Our ref: NO/2012/103478/01-L01
Your ref: 3/2012/0179
Date: 05 April 2012

**OUTLINE APPLICATION FOR A RESIDENTIAL DEVELOPMENT FOR THE
ELDERLY, COMPRISING OF 38 BUNGALOWS AND 40 RETIREMENT
APARTMENTS
LAND AT ACCRINGTON ROAD, WHALLEY, CLITHEROE**

We OBJECT to the proposed development as submitted on the following grounds:-

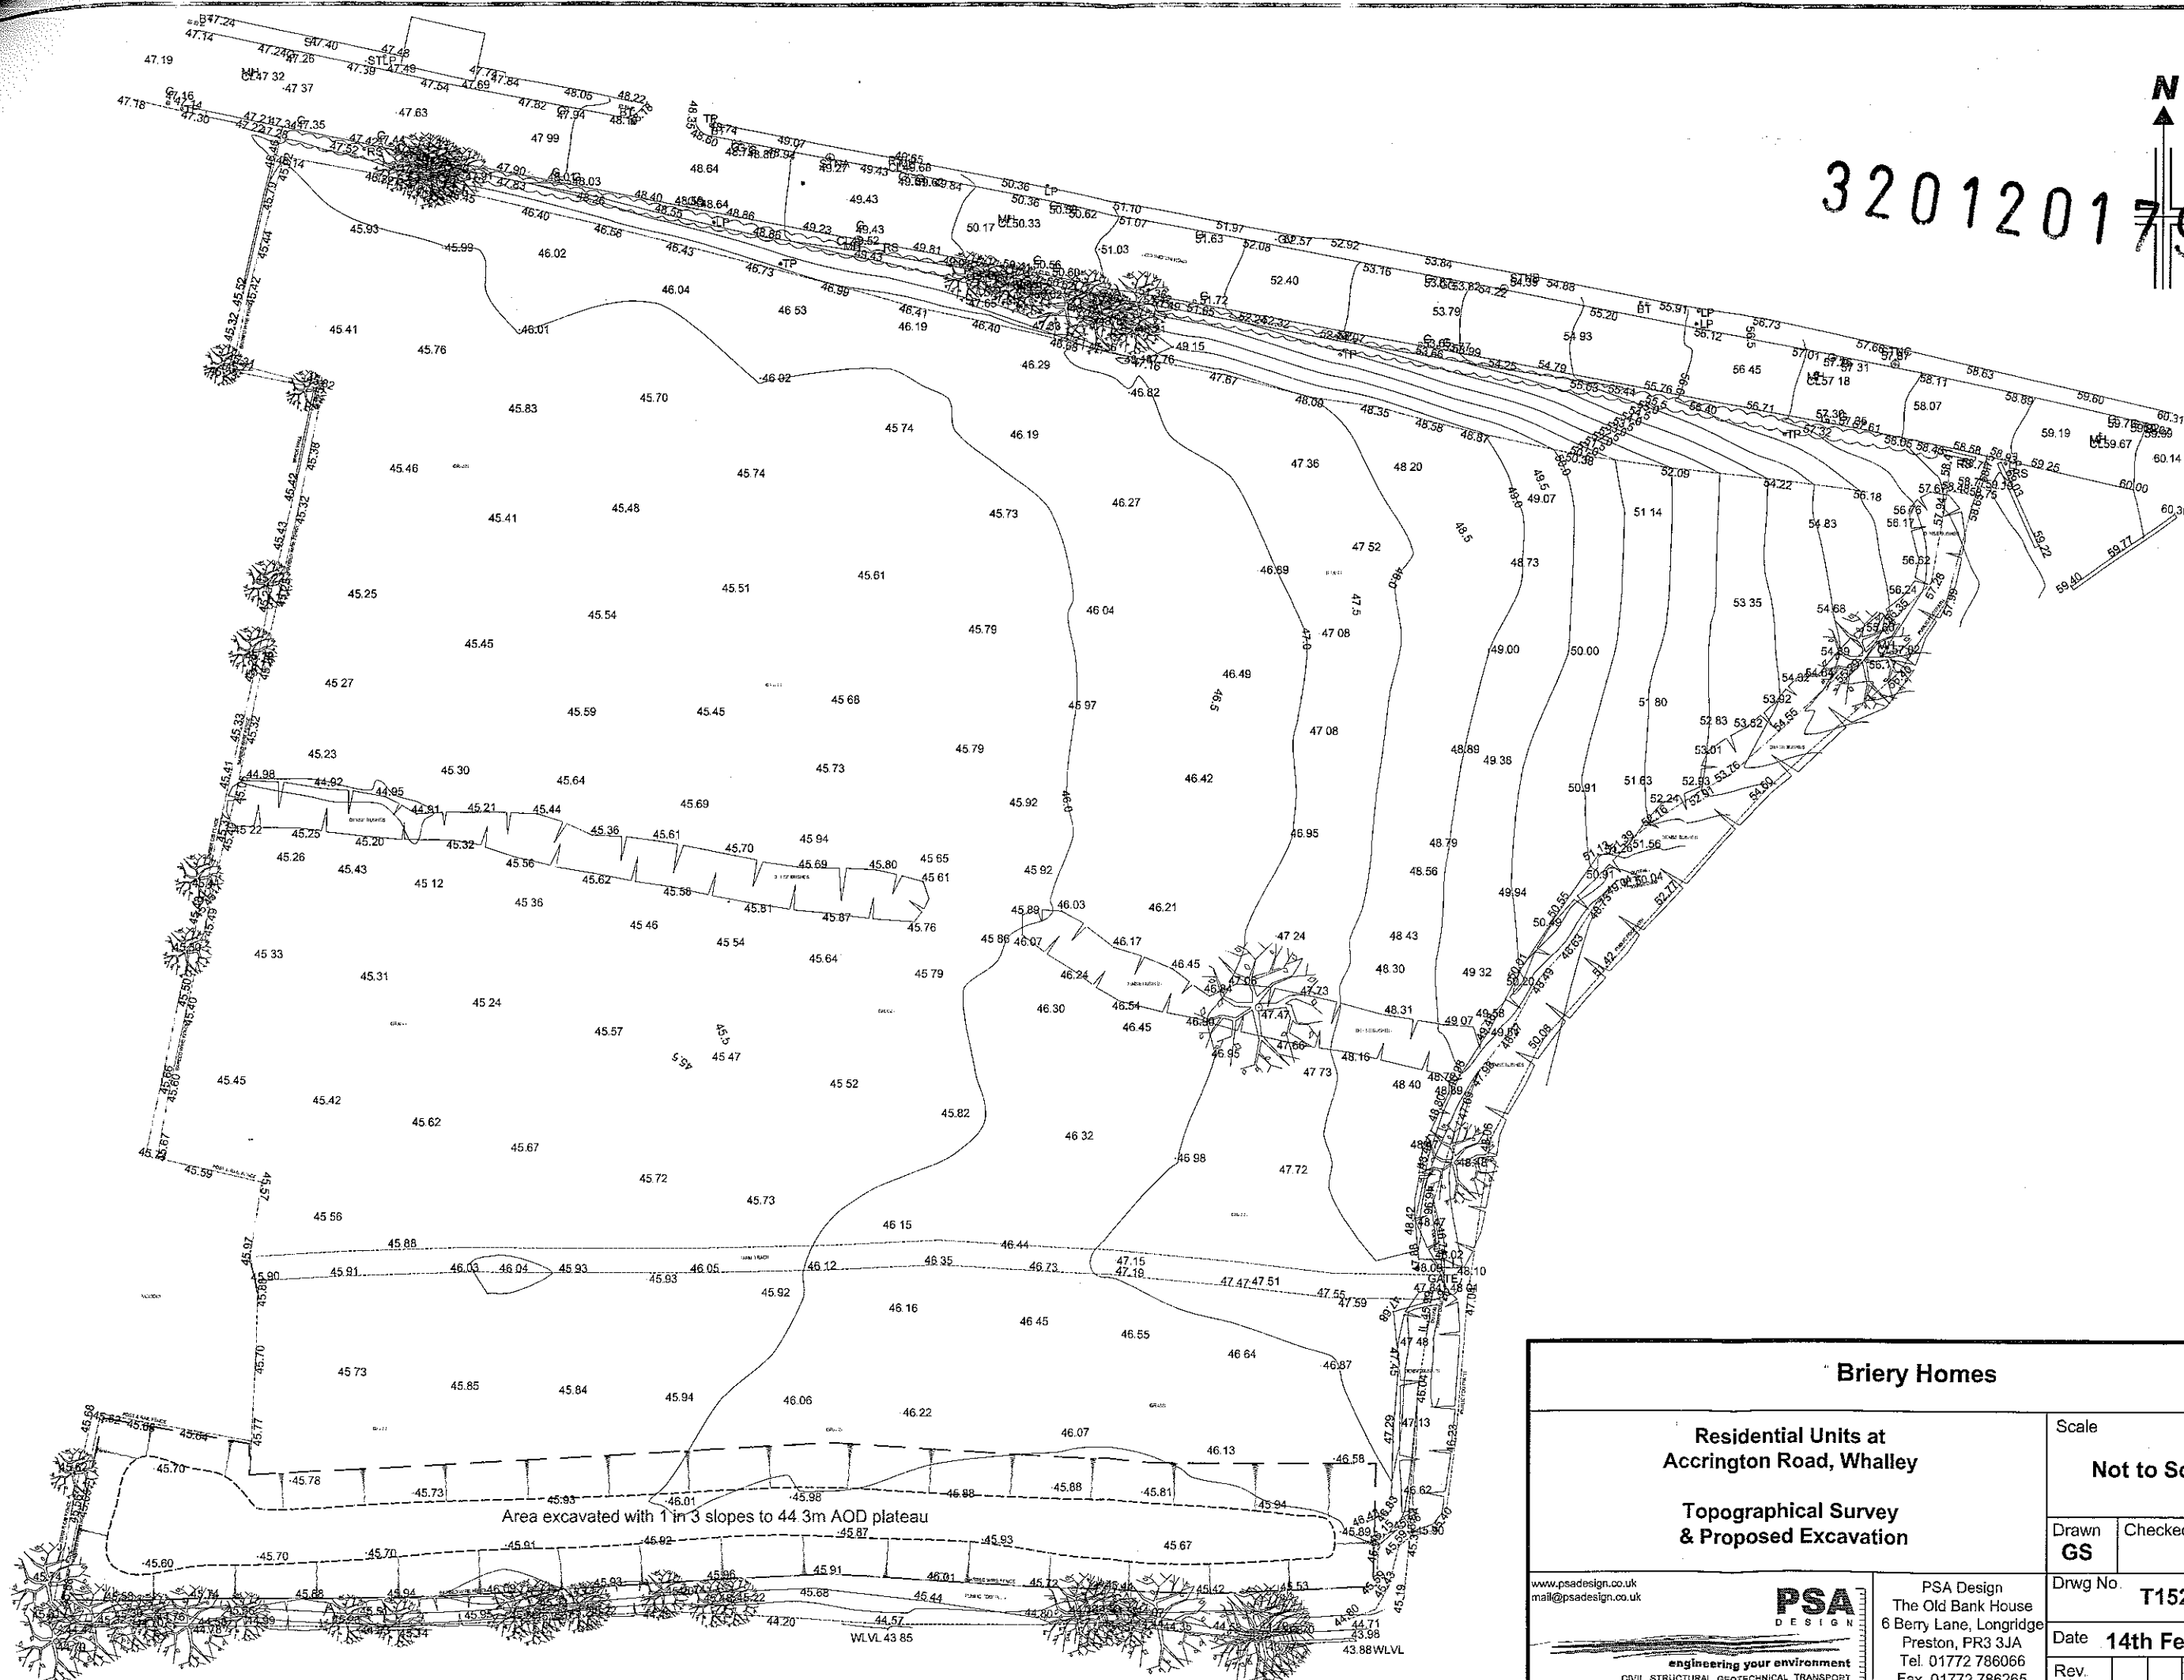
- 1) Finished Floor levels are recommended to be set 600mm above flood level and the surrounding land raised to 150mm below the finished floor level. This will infill the floodplain and increase the risk of flooding elsewhere.
- 2) The compensatory flood scheme proposes to excavate a basin parallel to the river. This is not acceptable because this will already be full of water when the peak flood occurs. Also, there is no outlet to the basin and it will fill with rainwater.
- 3) The River Calder is a designated Main River as defined by the terms of the Water Resources Act 1991 and the Land Drainage Byelaws. As such, our prior written Consent is required to plant any trees or shrubs within 8 metres from the
